RE: Sundown Solar Farm, Inverell Shire (SSD 8911)

Attachment 1 – BCD Recommendations - Sundown Solar Farm – Biodiversity Development Assessment Report

Attachment 2 – Detailed BCD comments - Sundown Solar Farm – Biodiversity Development Assessment Report

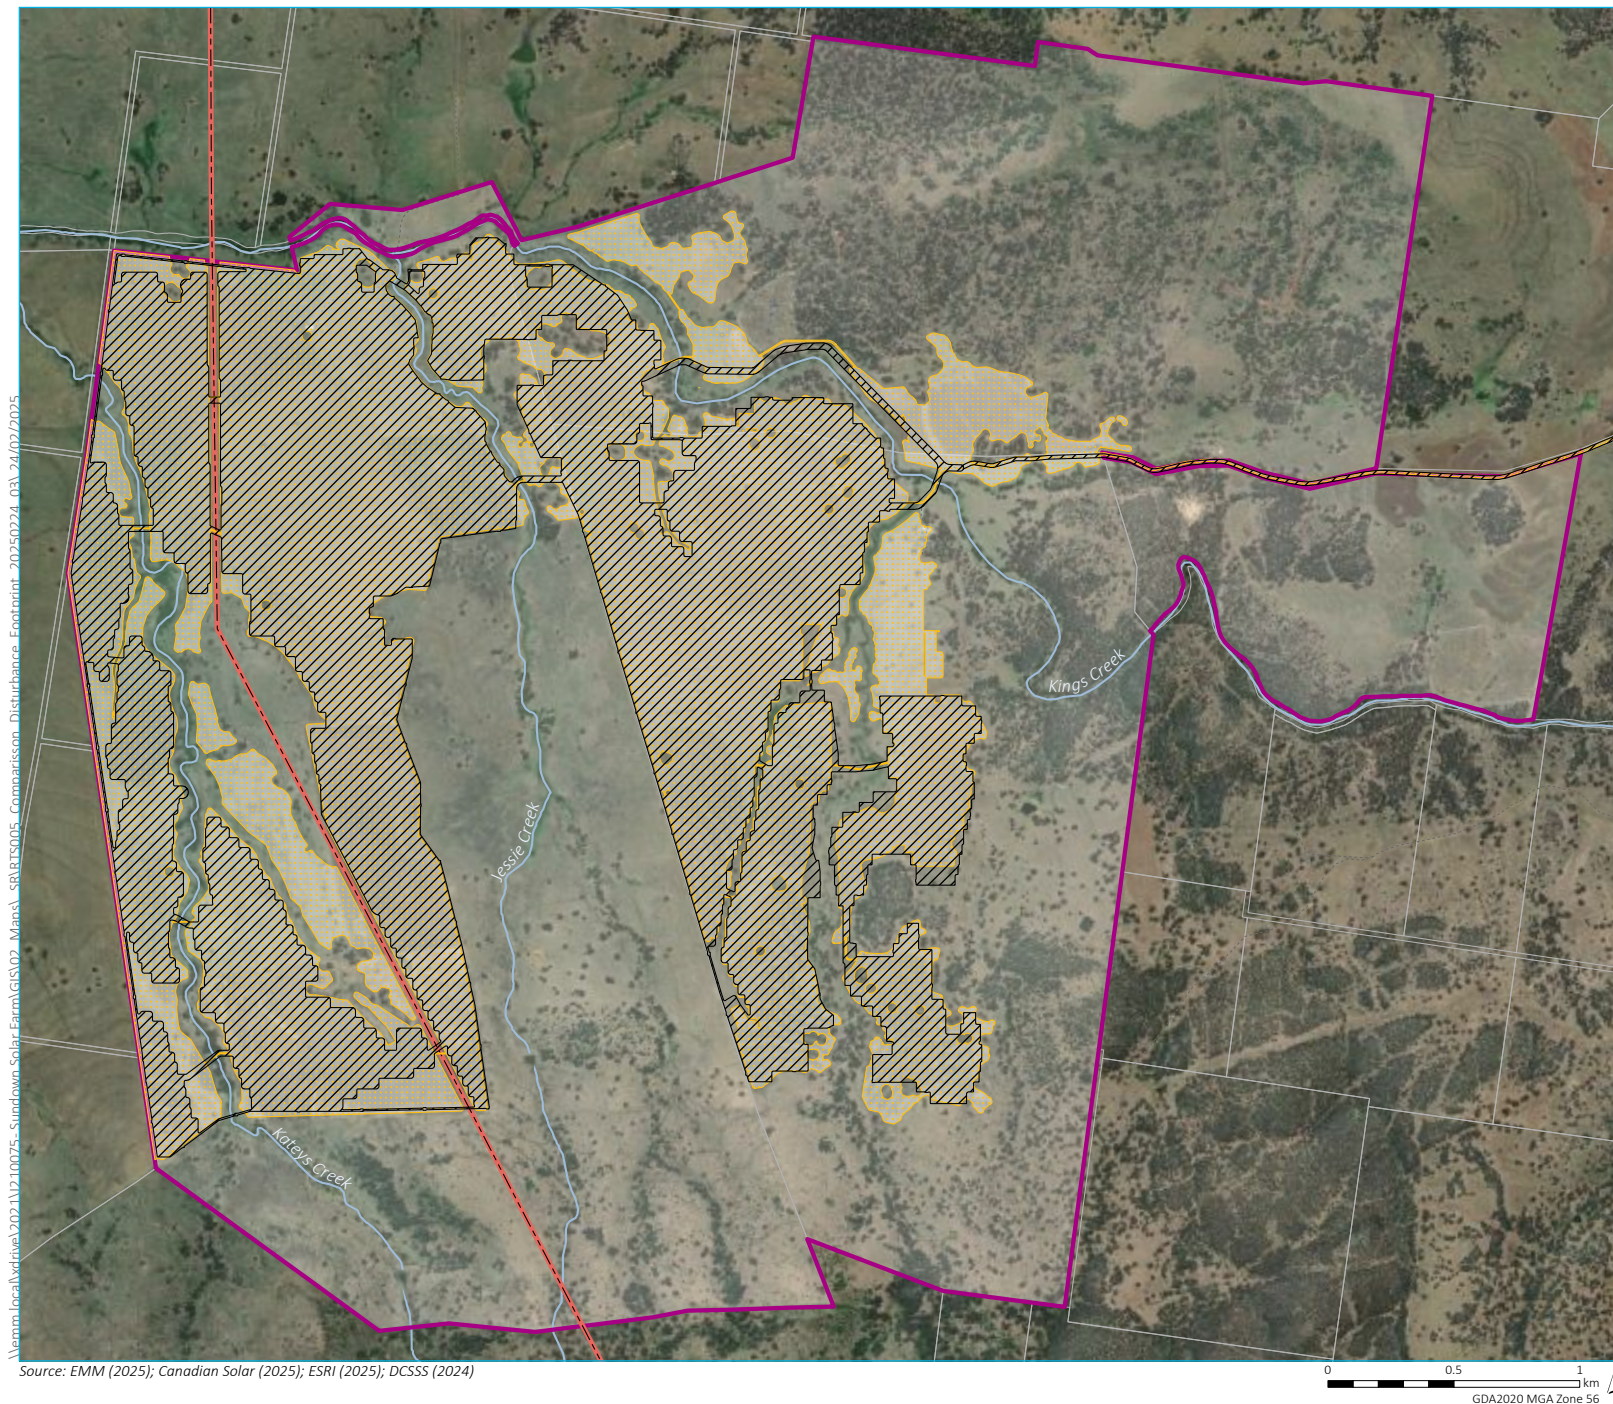
- 1.1 The proposed development footprint be revised to ensure all project areas and components are connected and include all connections in the assessment.

- 1.2 The proposed development footprint be revised to limit the creation of small, unviable 'islands' of retained habitat.
- 2.1 The consent authority note the proposal is likely to have a Serious and Irreversible Impact on the Box Gum Woodland CEEC.

- 2.2 The proposed development footprint be revised to further avoid and minimise impacts to woodland areas of the Box Gum Woodland CEEC.
- 2.3 The BDAR be revised to include additional and appropriate measures to minimise impacts on the Box Gum Woodland CEEC such as revegetation to improve connectivity between avoided areas and within riparian corridors.

Several parts of the development footprint presented in the Biodiversity Development Assessment Report (BDAR) and Environmental Impact Statement (EIS) and identified as potential solar array areas are not connected to any other part of the footprint (**Figure 1**). To construct solar panels in these areas would require road and cable connections to other parts of the footprint. All development components that would result in loss of biodiversity values are to be included in the development footprint and calculated in the total direct impact of the project.

The development footprint includes numerous small 'cut-outs' where isolated records of threatened flora species were identified and are proposed to be avoided (**Figure 2**). The BCD acknowledges this represents an effort to avoid and minimise impacts on threatened flora species. However, given their small area and proposed isolated locations surrounded by solar arrays and other infrastructure, we consider these retained areas are unlikely to provide viable habitat in the long-term. Therefore, unless the protection, management and long-term viability of these areas can be demonstrated, they should be included within the development footprint. We understand some other small areas proposed to be avoided have been excluded from the footprint to protect heritage values, however if biodiversity values are likely to be impacted these areas should be assessed as a loss in the BDAR.

- 1.1 The proposed development footprint be revised to ensure all project areas and components are connected and include all connections in the assessment.
- 1.2 The proposed development footprint be revised to limit the creation of small, unviable 'islands' of retained habitat.
2. The proposal requires revision to further avoid and minimise impacts to SAIL Box Gum Woodland and to include additional and appropriate measures to minimise impacts on the SAIL entity

However, based on our review of the BDAR and field observations, we have identified other potential opportunities to further avoid impacts on the SAIL entity (**Figure 3**), which include:

- revising the development footprint to further avoid woodland areas and better connect avoided areas.
- regularising boundaries between avoided areas and the development footprint to reduce the perimeter, hence reducing edge effects and improving viability of avoided areas.
- modifying the location of a proposed internal access road to align with an existing track instead of traversing intact woodland.
